ENG-CDR23021-R2-FDR-S1.pdf Markup Summary

Subject: SW - Textbox
Page Index: 1
Date: 4/2/2024 3:32:00 PM
Author: Glenn Reese - EPC Stormwater
Color: ■
Layer:
Space:
Page Label: 1

Subject:
Page Index: 4
Date: 4/9/2024 12:11:00 PM
Author: Jeff Rice - EPC Engineering Review
Color: ■
Layer:
Space:
Page Label: 4

STORMCAD NETWORK LAYOUT: SEGMENT 1

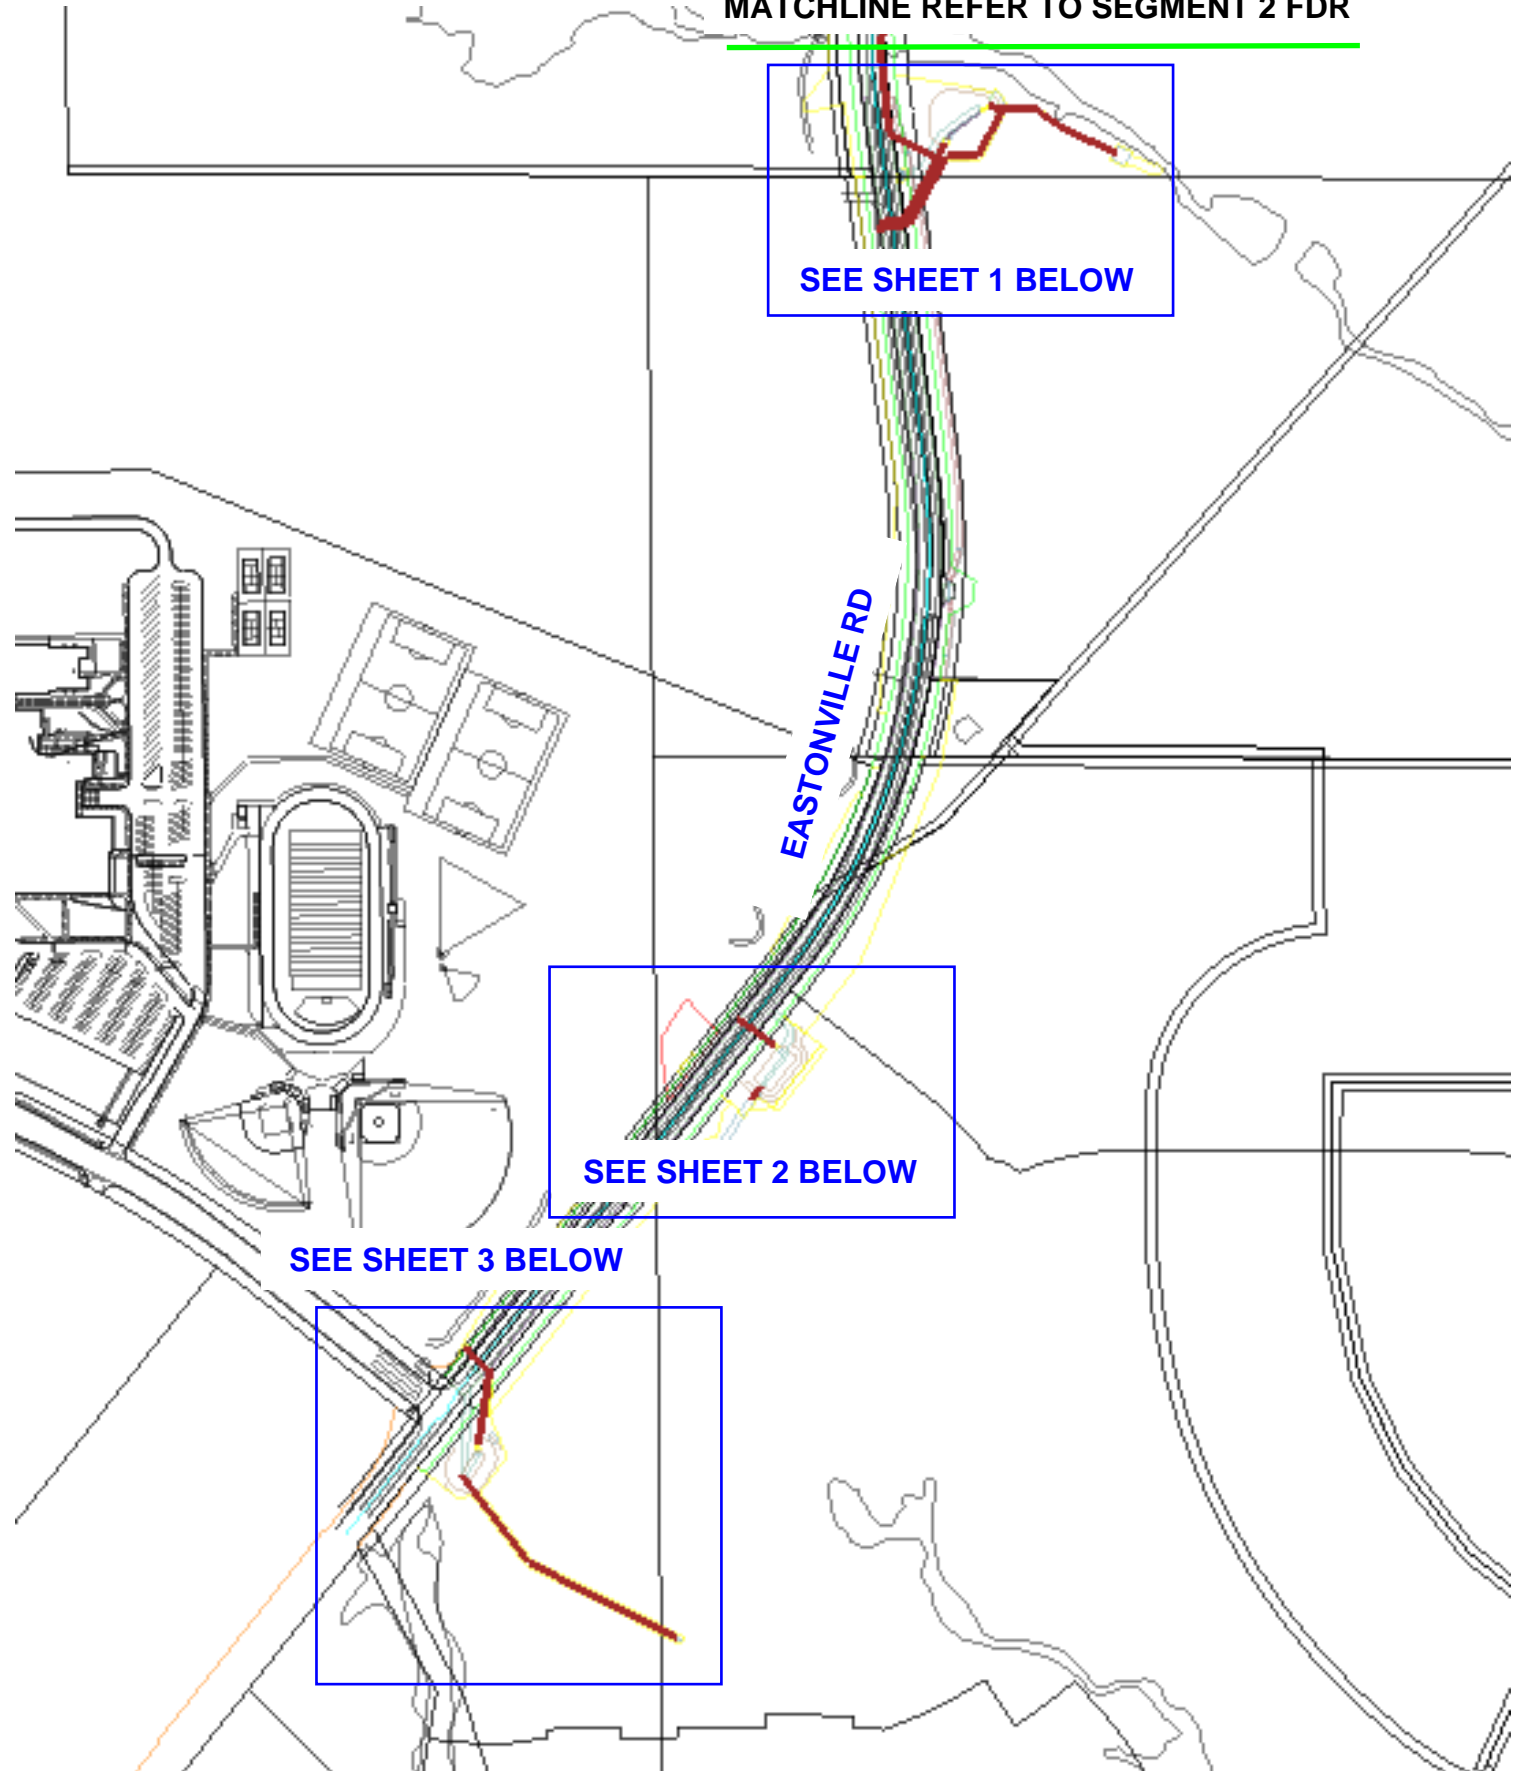
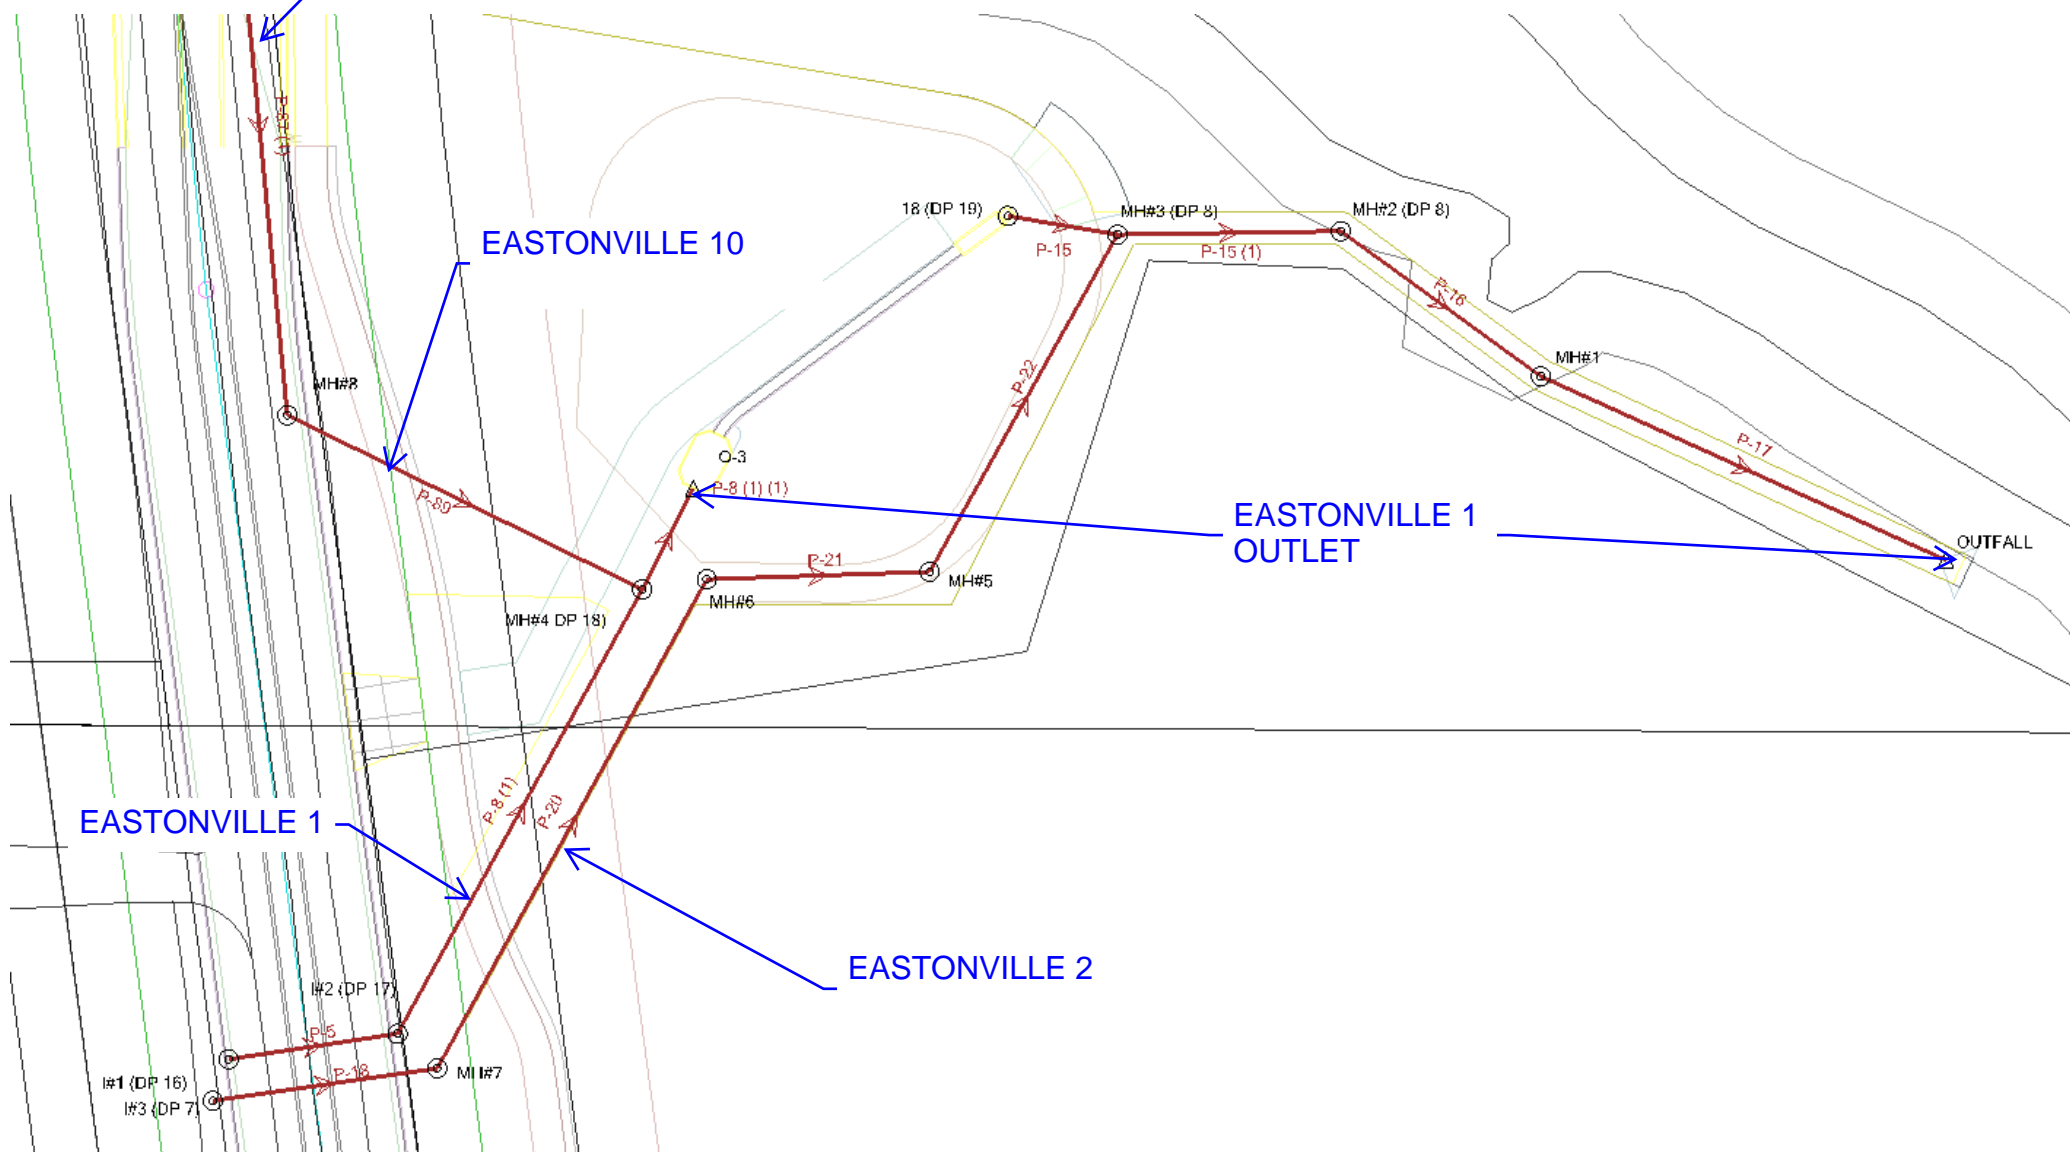
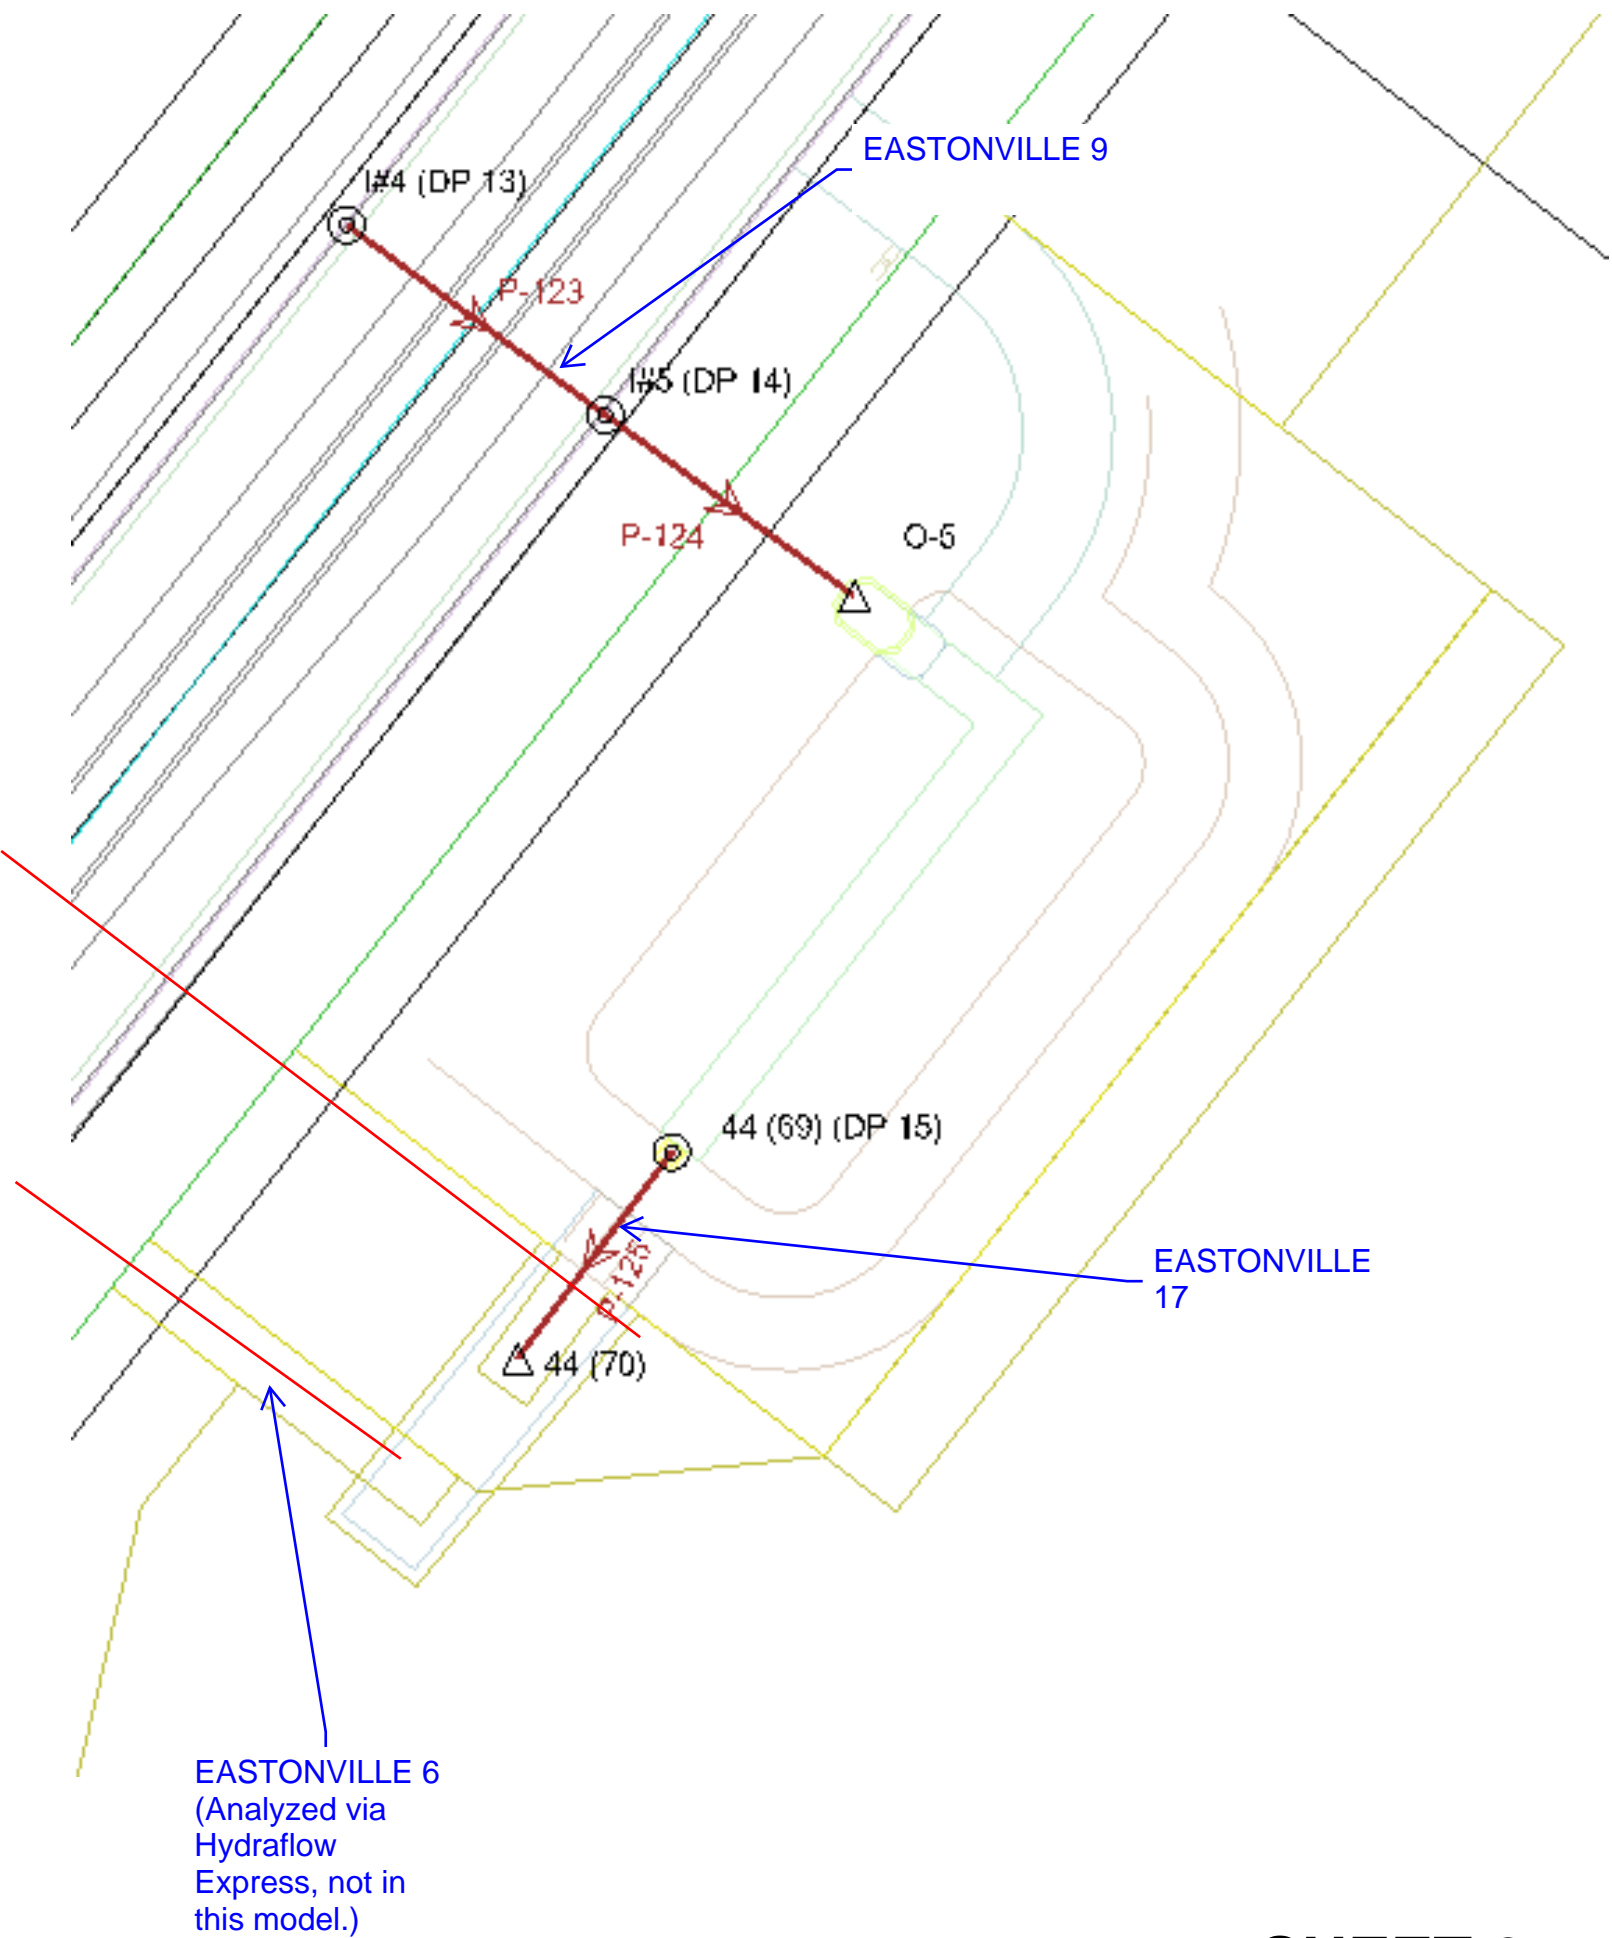
Explain what difference is between DP's 18/18U and 19/19U. Is a 19 and 19U both needed? They have the same flows/same basin.

Same basins/DPs are being combined at these DP's please delete duplicate
